Our ref: DOC20/928713-14

Your ref: MP 05_0038 MOD 1

Major Project modification - Tinonee Residential Subdivision

I refer to your email dated 10 November 2020 requesting comment from Biodiversity and Conservation Division (BCD) of the Department of Planning, Industry and Environment in relation to a modification application for the Tinonee Residential Subdivision (MP 05_0038 MOD 1) located at The Bucketts Way, Taree South (Lot 542 DP 1113791, Lot 156 DP 753202 and Lot 53 DP 836998) in the Mid-Coast local government area.

Figure 13 - Location of *Diuris flavescens*

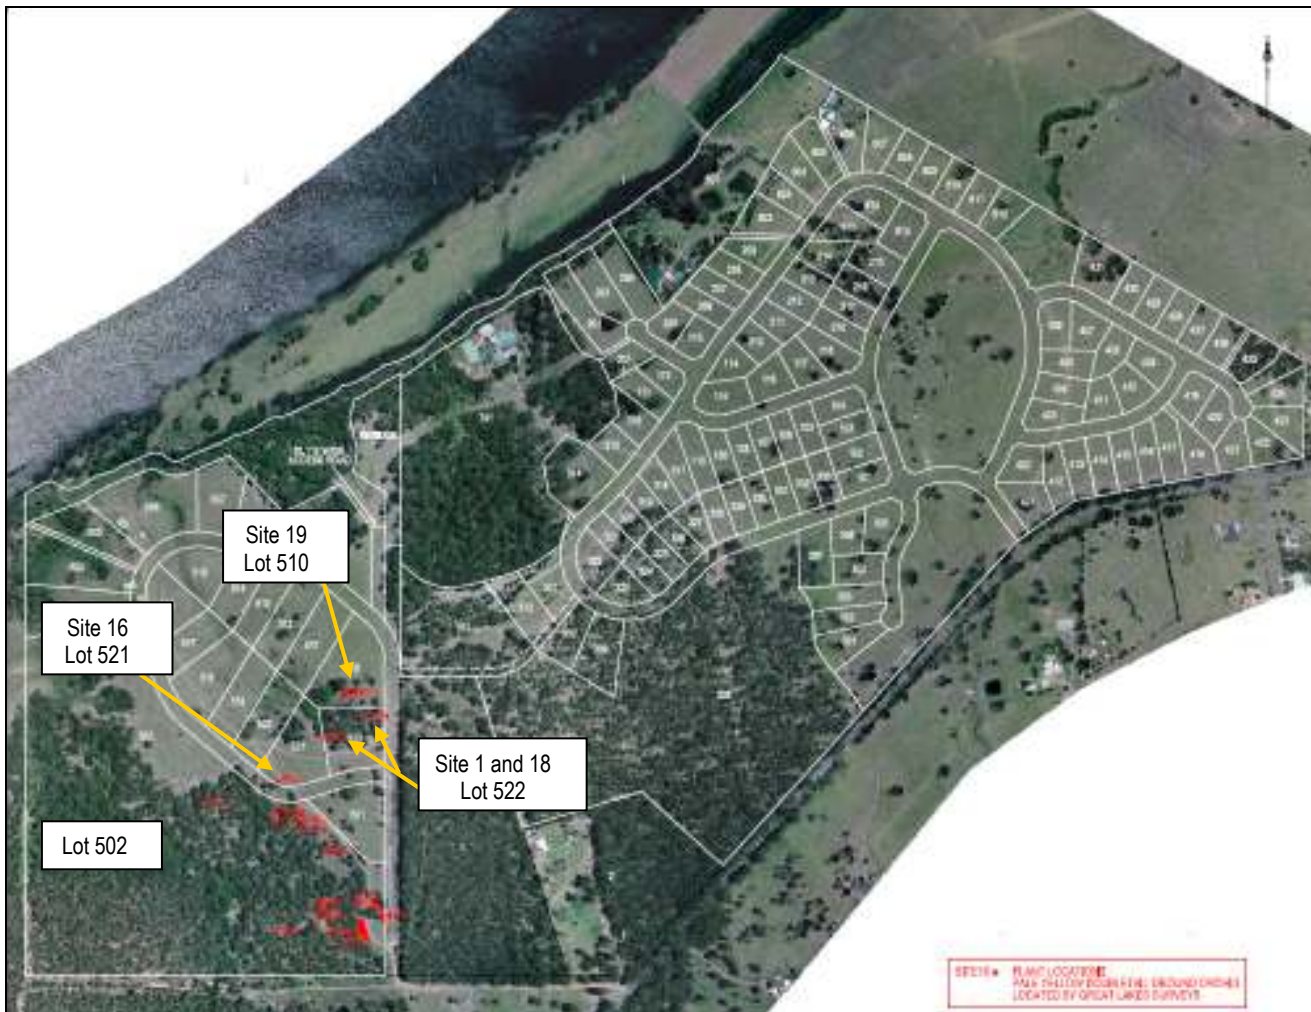
2. A survey for Pale Yellow Doubletail orchid (*Diuris flavescens*) should be undertaken

The Pale Yellow Doubletail (*Diuris flavescens*) is a threatened terrestrial orchid listed as endangered under the *Biodiversity Conservation Act 2016* and critically endangered under the *Environmental Protection and Biodiversity Conservation Act 1999*. It was detected on the Tinonee development site during targeted surveys in spring 2008.

The Ecological Assessment for Subdivision Modification (Biodiversity Australia Pty Ltd, Sept 2020) suggests that a targeted survey for this species has not occurred within the last five years, as required by Surveying threatened plants and their habitats – NSW survey guide for the Biodiversity Assessment Method (DPIE 2020). This survey guide states that surveys undertaken more than five years prior to the proposal lodgement date may be used to inform the assessment process but cannot be used in place of a targeted species survey. This is to ensure results are current with respect to site condition, structural attributes and species' presence.

The proponent should undertake a targeted survey for *Diuris flavescens* for the proposed modification or provide an expert report in accordance with 6.5.2 of the BAM. Alternatively, the species can be assumed present on the development lands only.
